Appendix A – Submissions Register

New Rouse Hill Hospital

This Submissions Register has been prepared by Architectus Australia Pty Ltd (Architectus) on behalf of Health Infrastructure NSW (Health Infrastructure) in support of the State Significant Development Application (SSDA) (SSD-96248991) for the Rouse Hill Hospital located at the corner of Commercial Road and Windsor Road, Rouse Hill.

**DRAWING TITLE**  
 SSDA - SITE PLAN PROPOSED

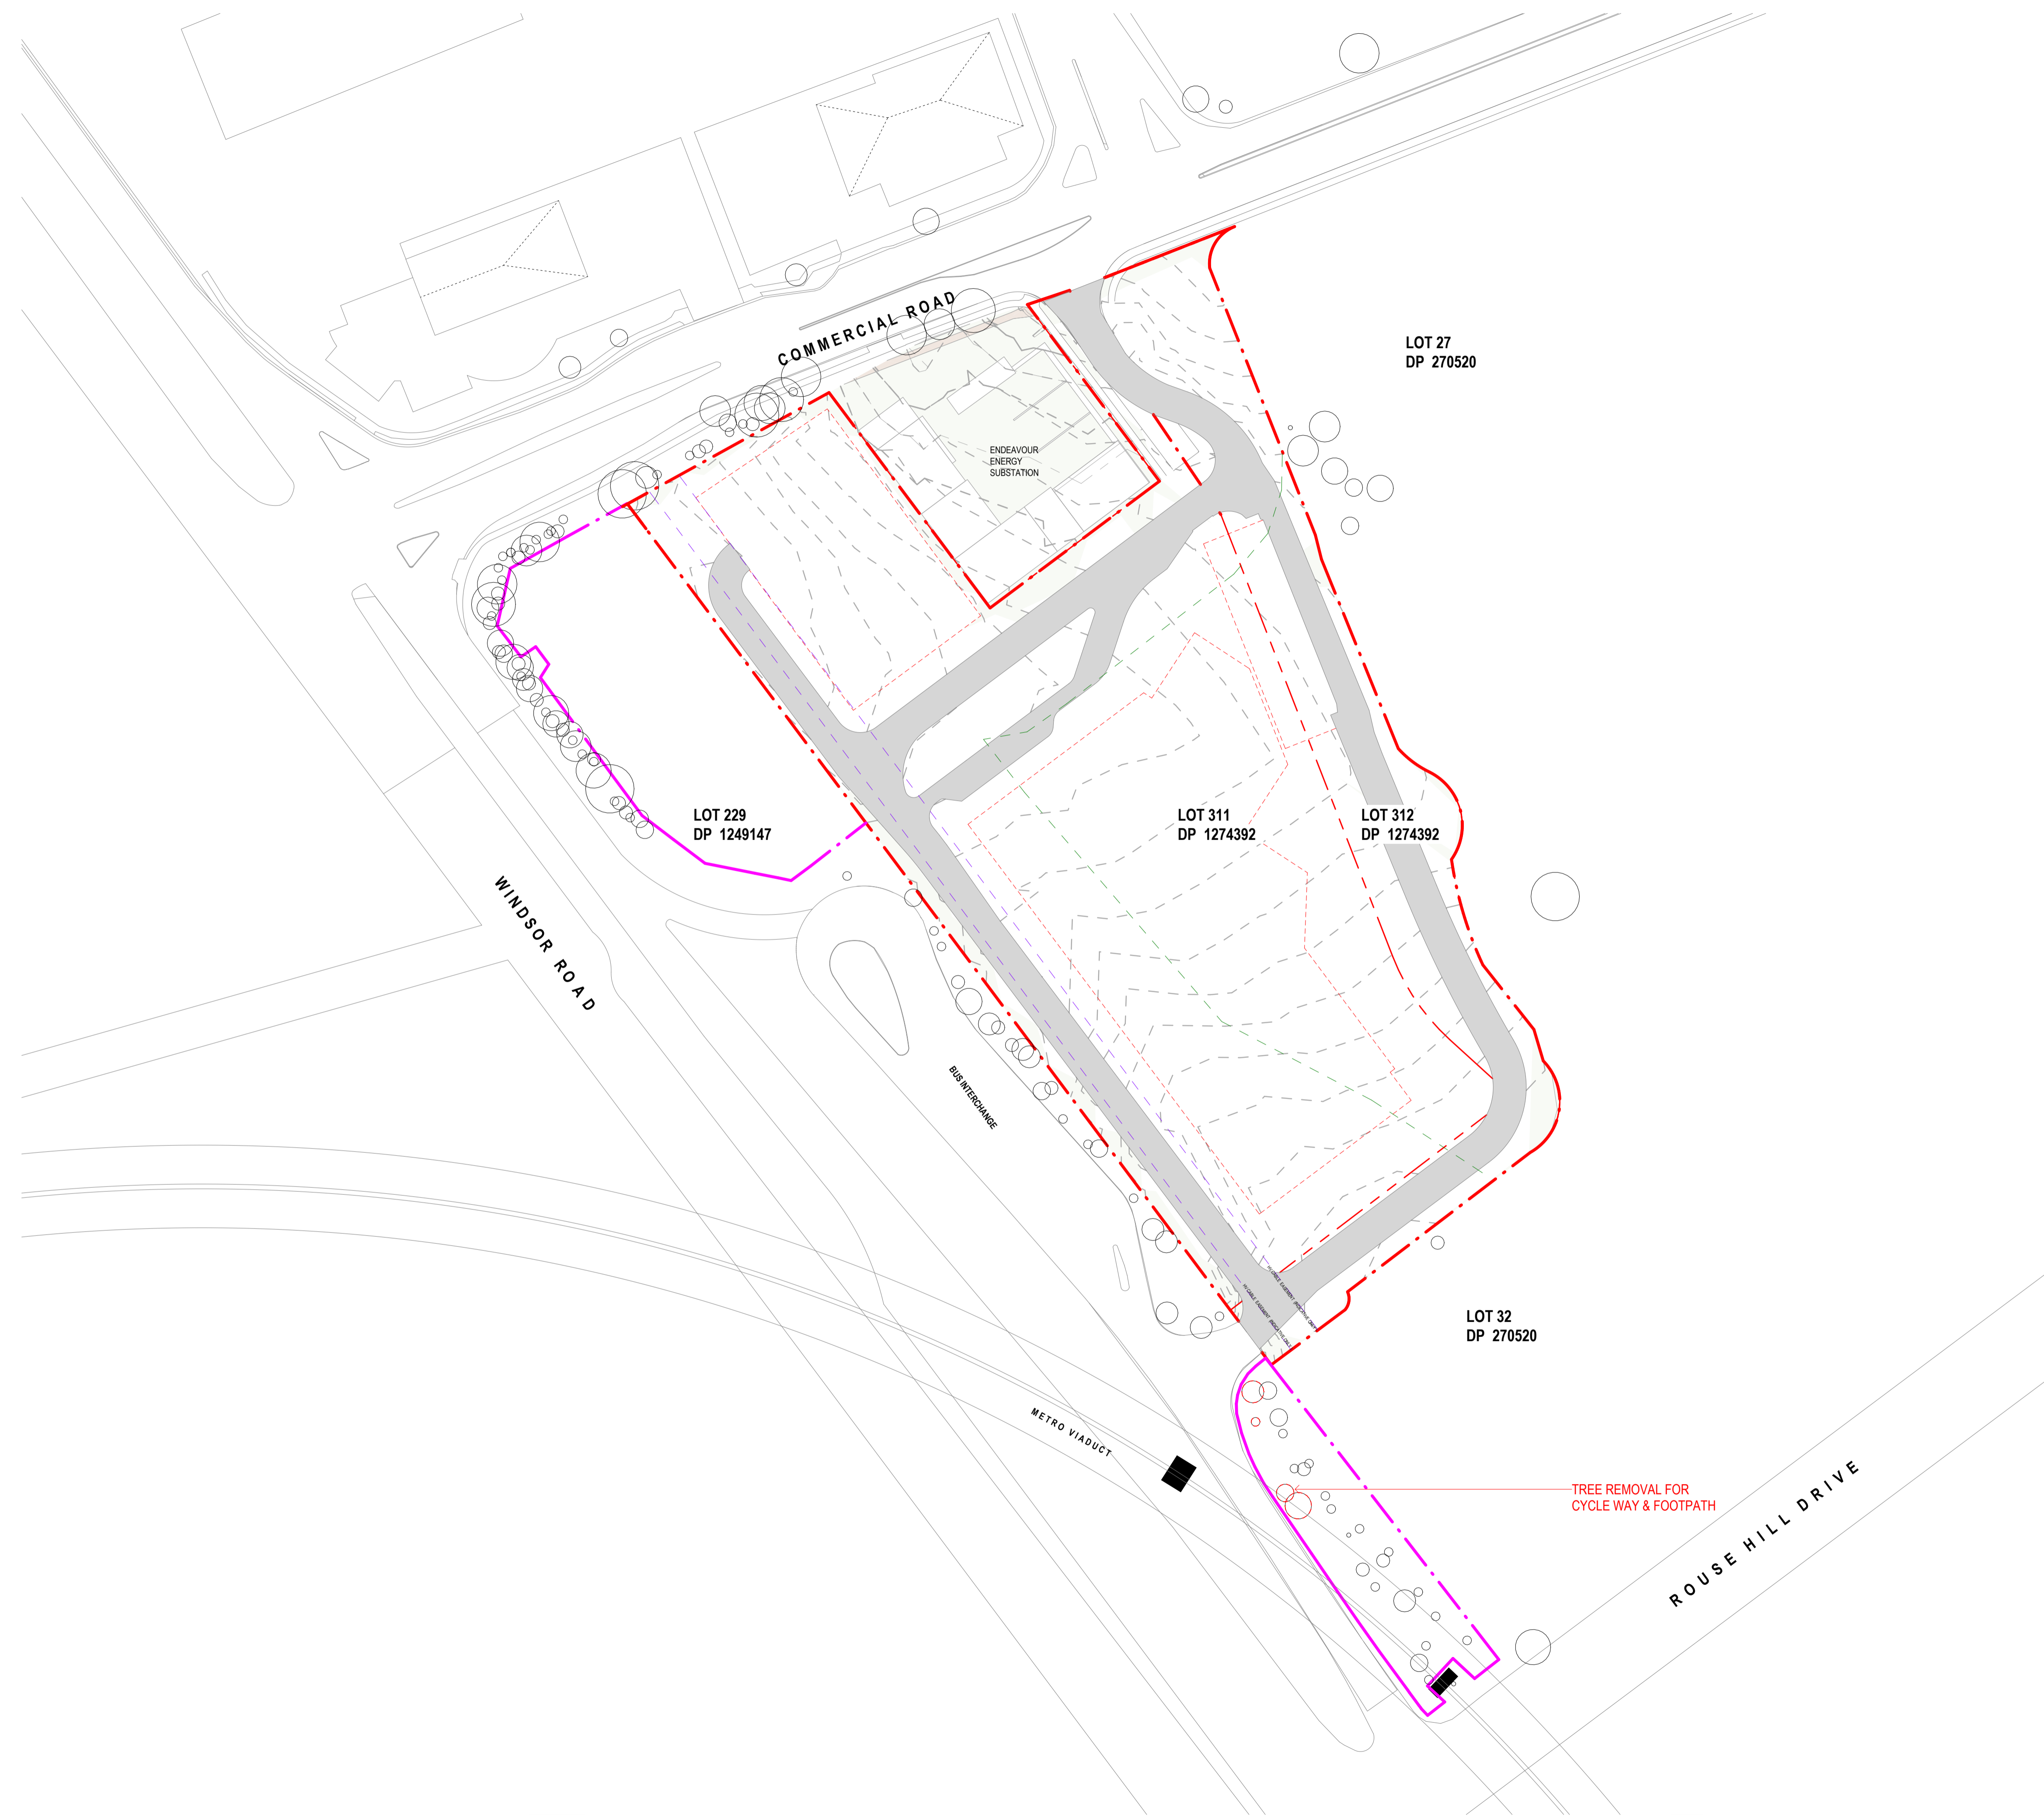
Issue	Section where issues addressed in submissions report
Site Sheds	
<p><i>(Construction and Site Management)</i></p> <p>The drawing SSDA-Site Plan Proposed shows the provision of site sheds on Lot 229 DP 1249147 (corner of Windsor Rd and Commercial Rd). The Landscape Plans appear to indicate the same. The Department considers that the site sheds should be removed upon completion of the works with this area being appropriately treated/finished. Clarification is sought on the intended outcome for this parcel of land.</p>	Section 4.11 - Other
Site Contamination	
<p><i>(Contamination)</i></p> <p>The Detailed Site Investigation (DSI) for the Proposed Rouse Hill Main Hospital states that the site can be made suitable for the proposed development by undertaking the additional investigations and Human Health Risk Assessment (HHRA) and if required, preparing and implementing a RAP. The recommended additional investigations must be undertaken as soon as possible, and a RAP prepared if required and submitted with the Response to Submissions, so that a definitive statement of the suitability of the site for the development can be made to satisfy the requirements of State Environmental Planning Policy (Resilience and Hazards) 2021.</p>	<p>Section 4.4 - Contamination and geotechnical suitability</p> <p>Appendix G - Contamination and Remediation Response</p> <p>Appendix H - Advice letter - DSI and Tier 2 Human Health Risk Assessment</p>
